Office of
Environment
& Heritage

DOC18/189938
SSD 8574

Exhibition of Waitara Public School redevelopment, 48-58 Myra Street, Wahroonga - SSD 8574

Attachment 1 – Office of Environment and Heritage (OEH) comments Waitara Public School redevelopment, 48-58 Myra Street, Wahroonga - SSD 8574

SITE DEMOLITION PLAN
SCALE 1:300

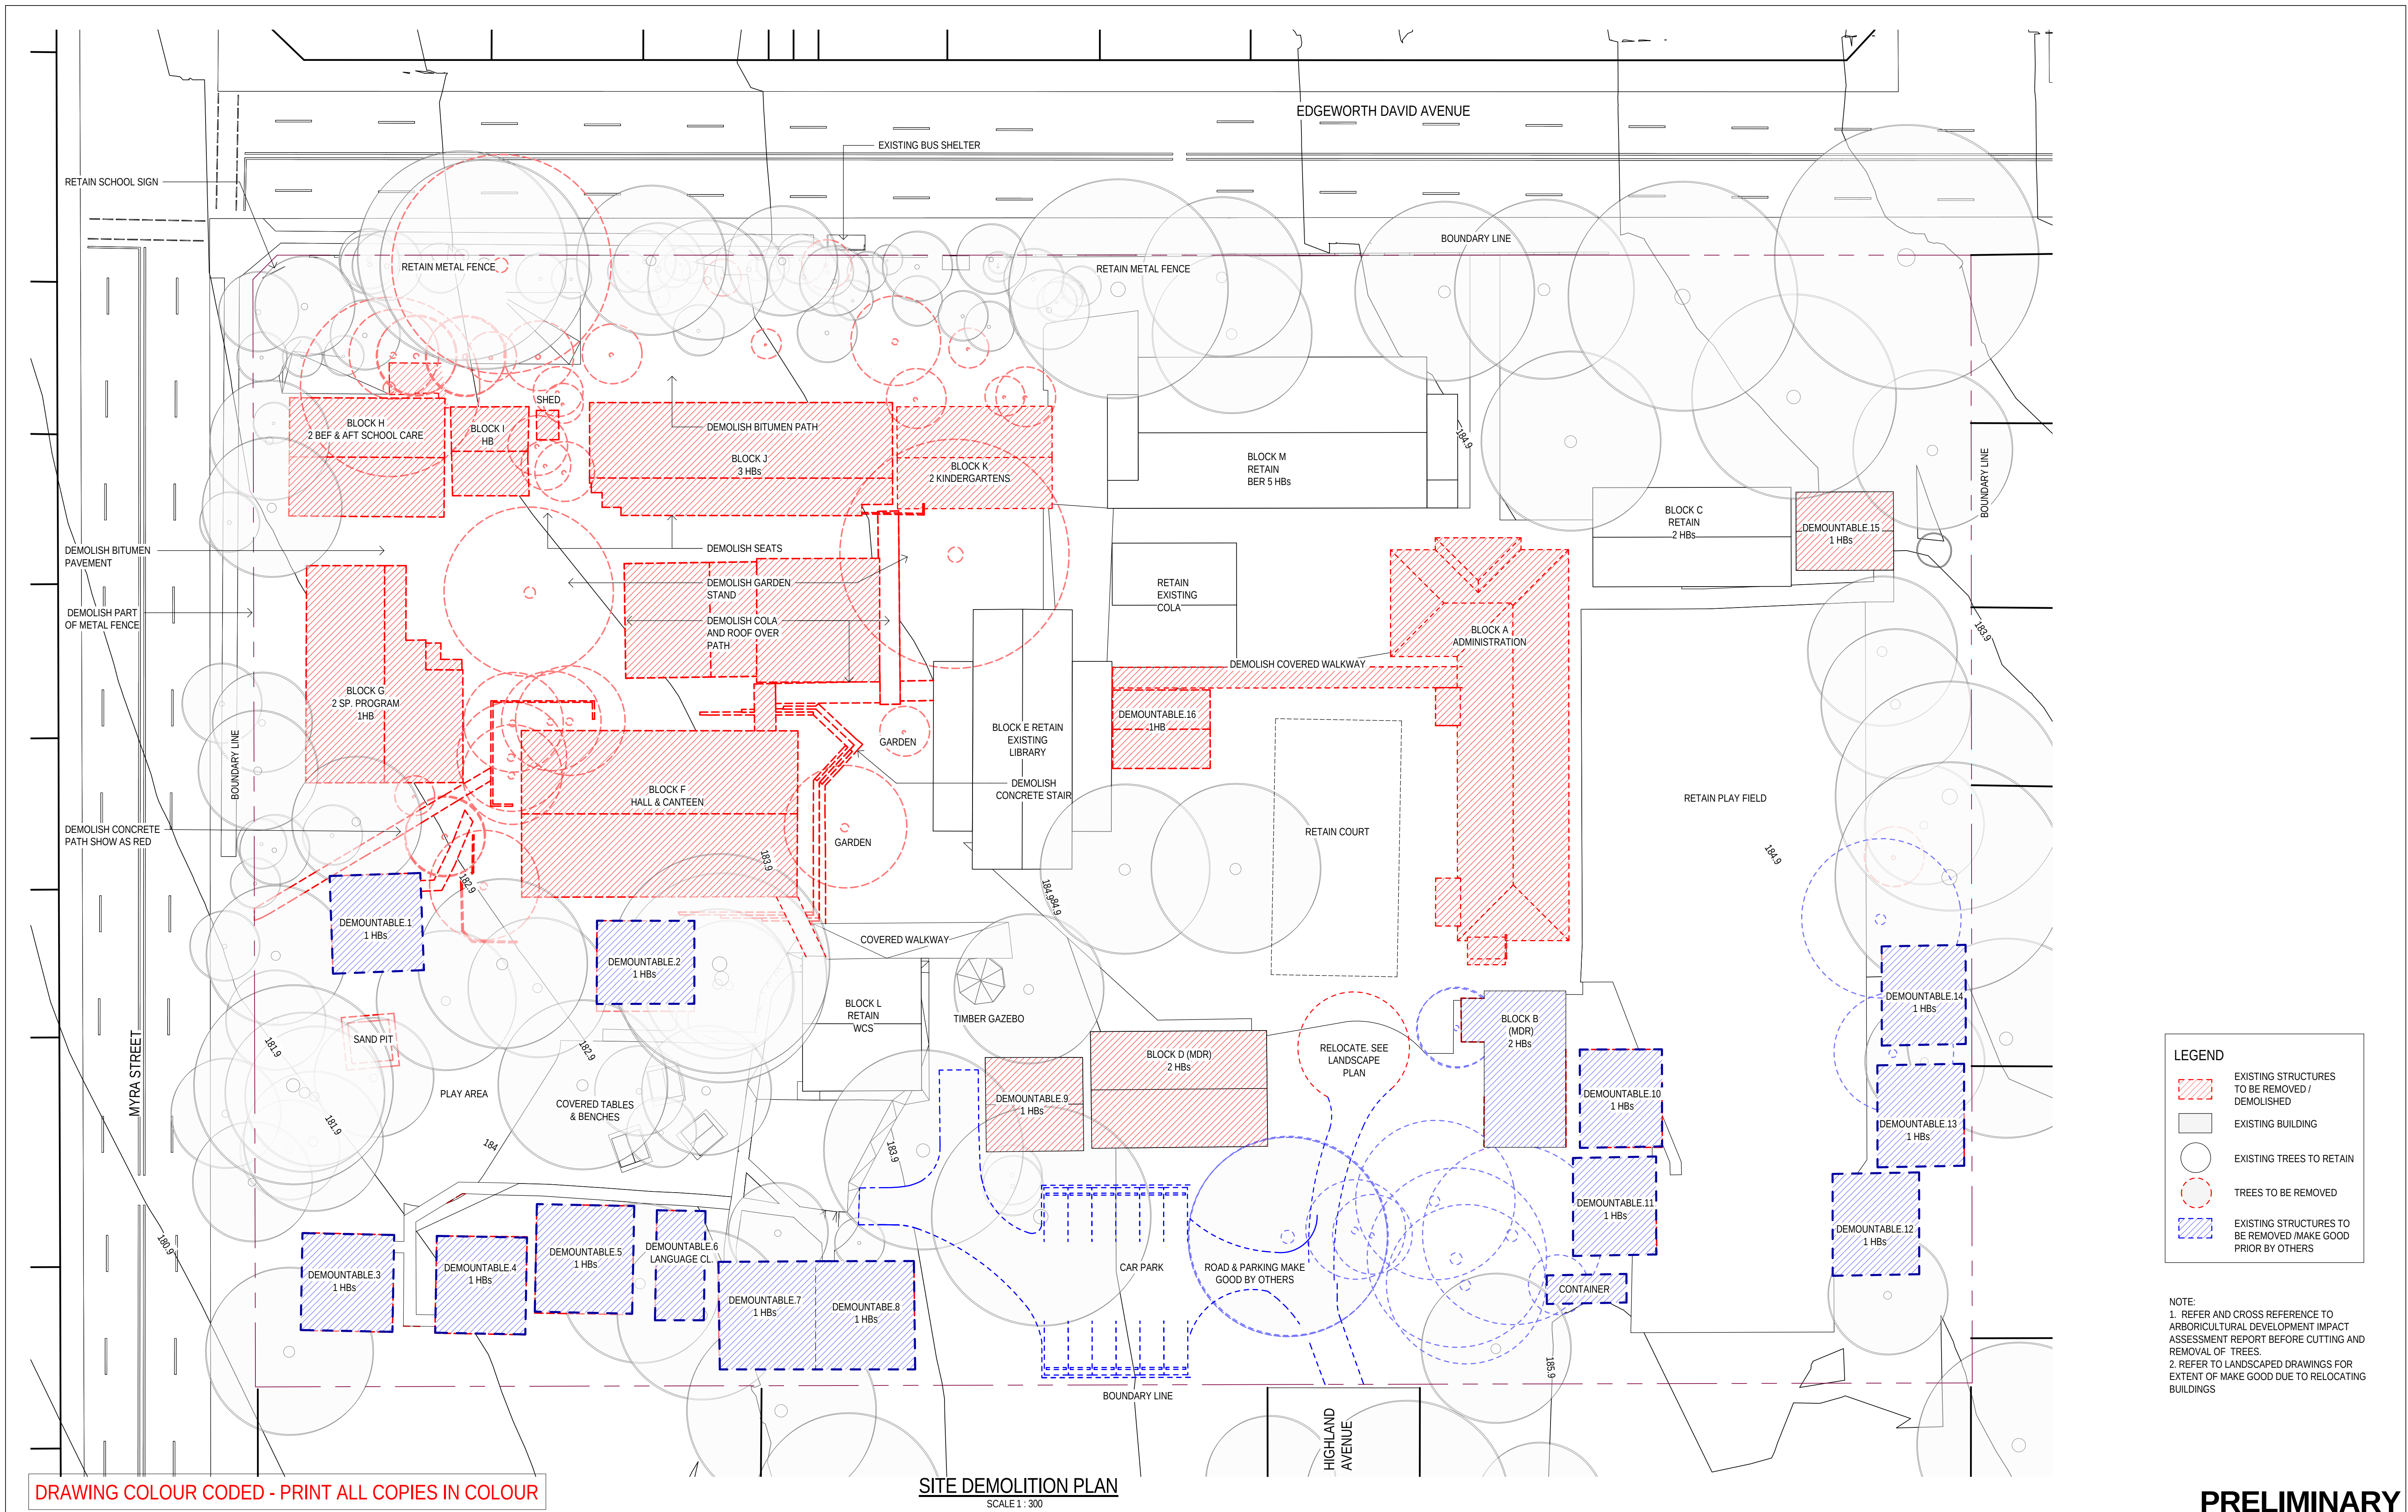
- The site demolition plan (Figure 3) shows a greater number of trees being removed than 23 with approximately over 30 trees shown in red as removed. The plans need to be updated to clarify the number of trees removed.
